# EROSION AND STORMWATER QUALITY CONTROL PERMIT (ESQCP) EL PASO COUNTY APPLICATION AND PERMIT

EPC Project Number: SF2323

INITIAL GRADING AND EROSION CONTROL PLAN
 PROJECT NO. 21085-03CSCV
 DRAWING NO.

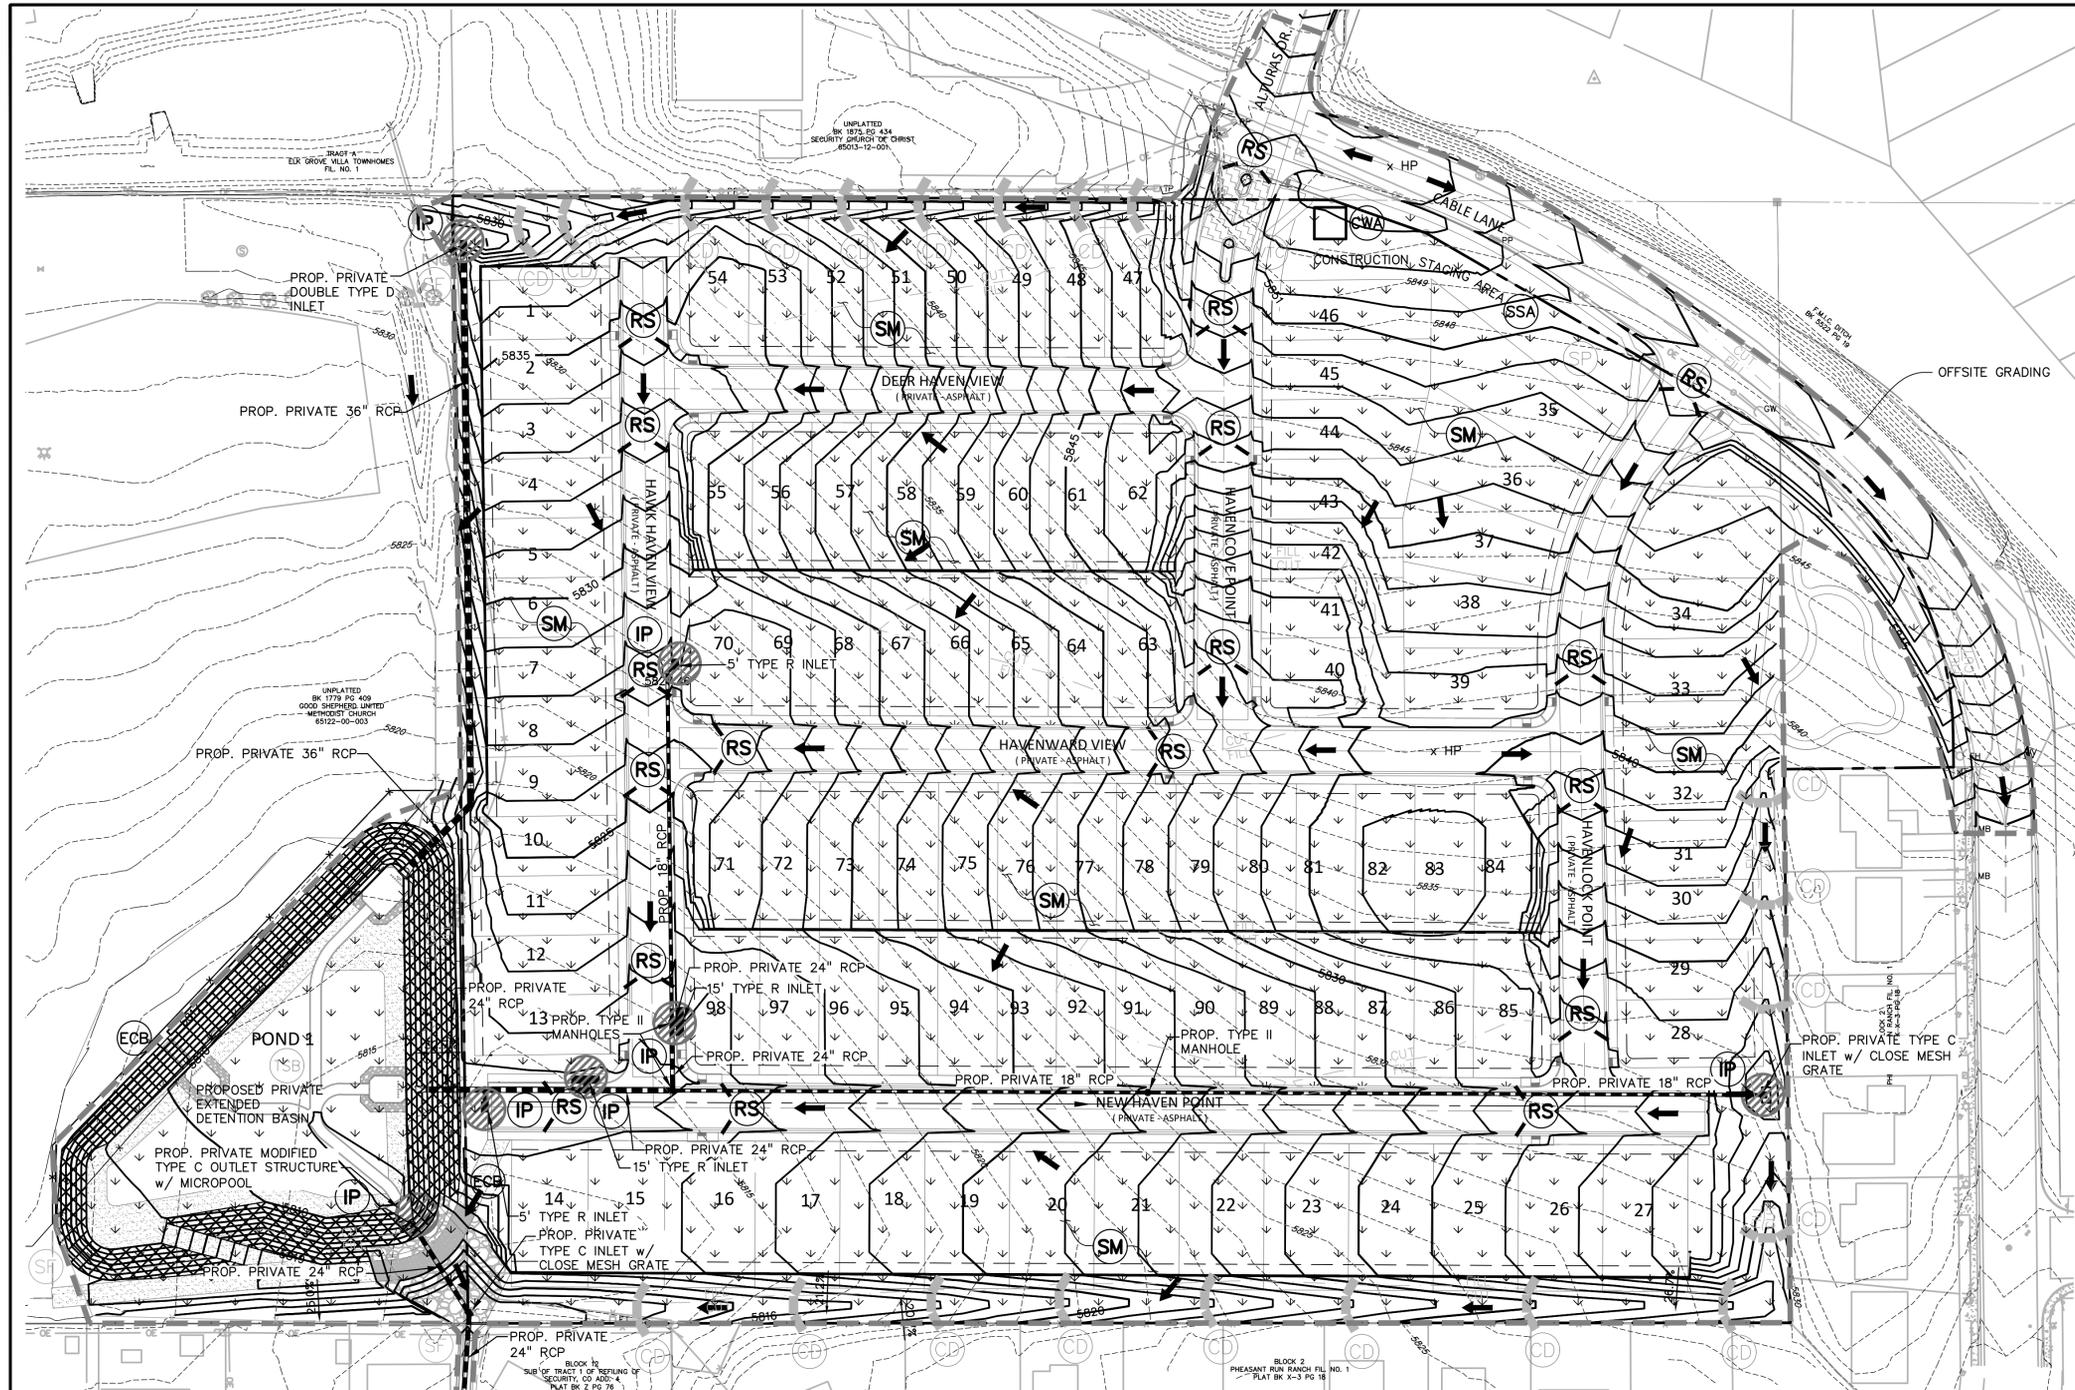
13.6ac on Sht 1 of GEC Plan. Revise to remove discrepancy.
